**Addendum No. 1**

RE: Contract ID C203834

**Pitt, Edgecombe Counties**

US-13/NC-11 From NC-903 To 1,180 Feet North of Bridge #383

Project No.	Sheet No.
2016CPT.02.04.10741.2, ETC.	8

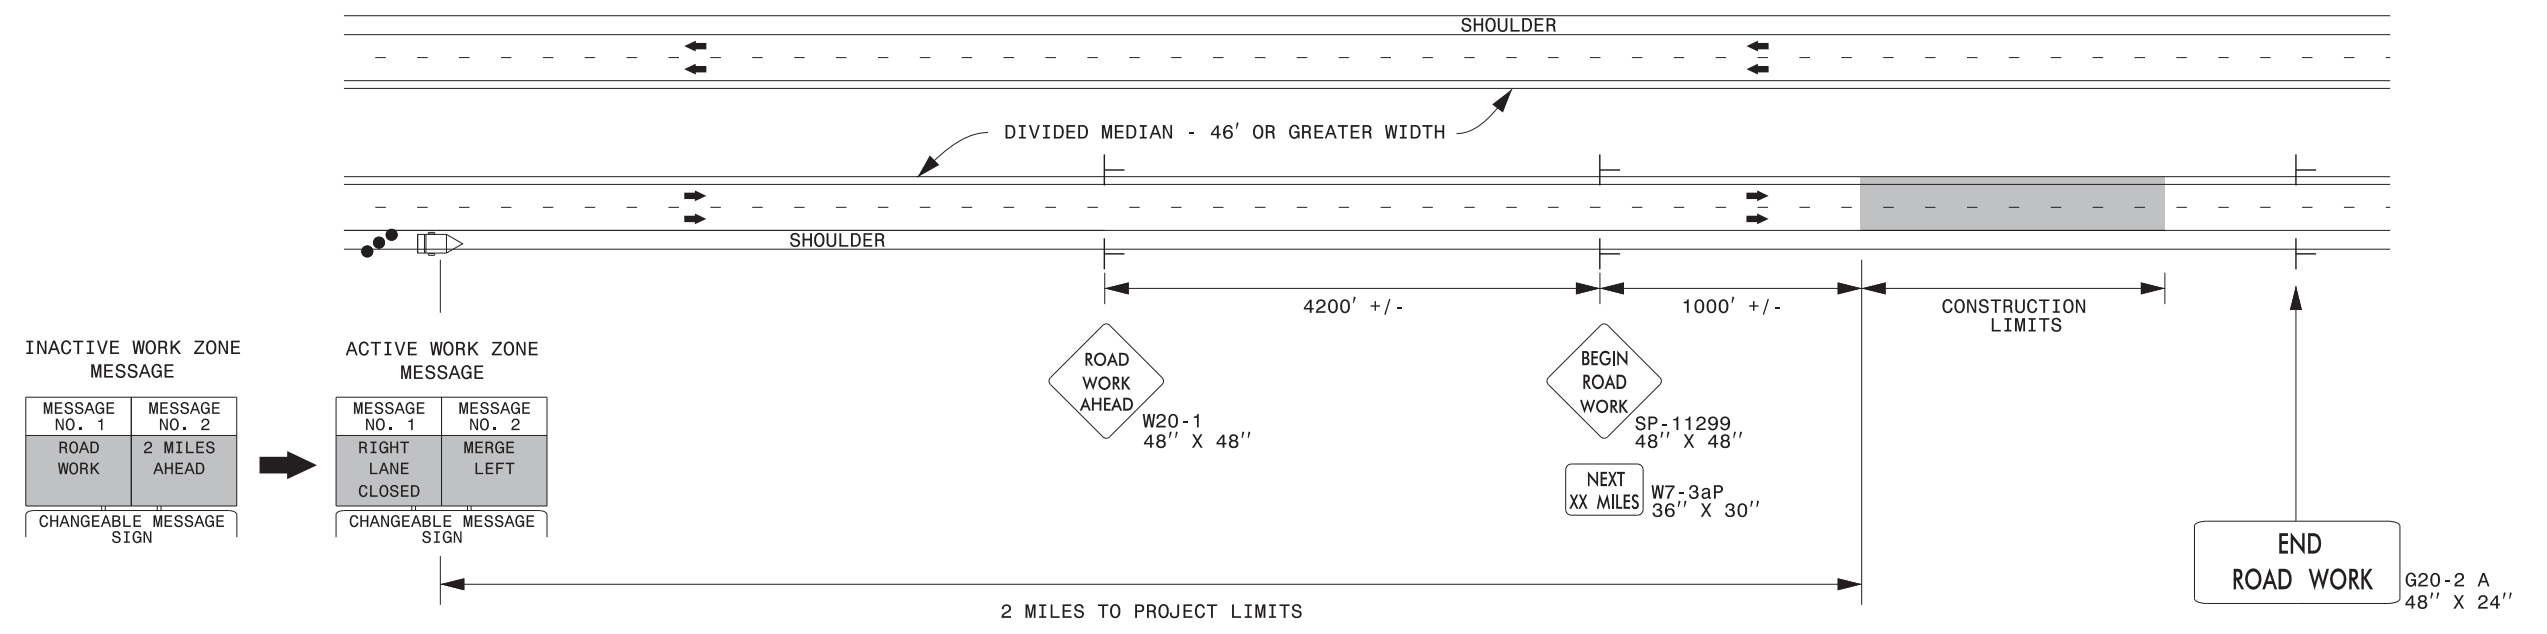
Sheet No.	Revisions
9	Revised the Summary of Quantities to reflect the below noted pay item addition

Please void Sheet No. 9 in your plans and staple the revised Sheet No. 9 thereto.

<u>Item</u>	<u>Description</u>	<u>Old Quantity</u>	<u>New Quantity</u>
025-4810000000-E- 1205	Paint Pavement Marking Lines (4")	NEW ITEM	154,000 LF
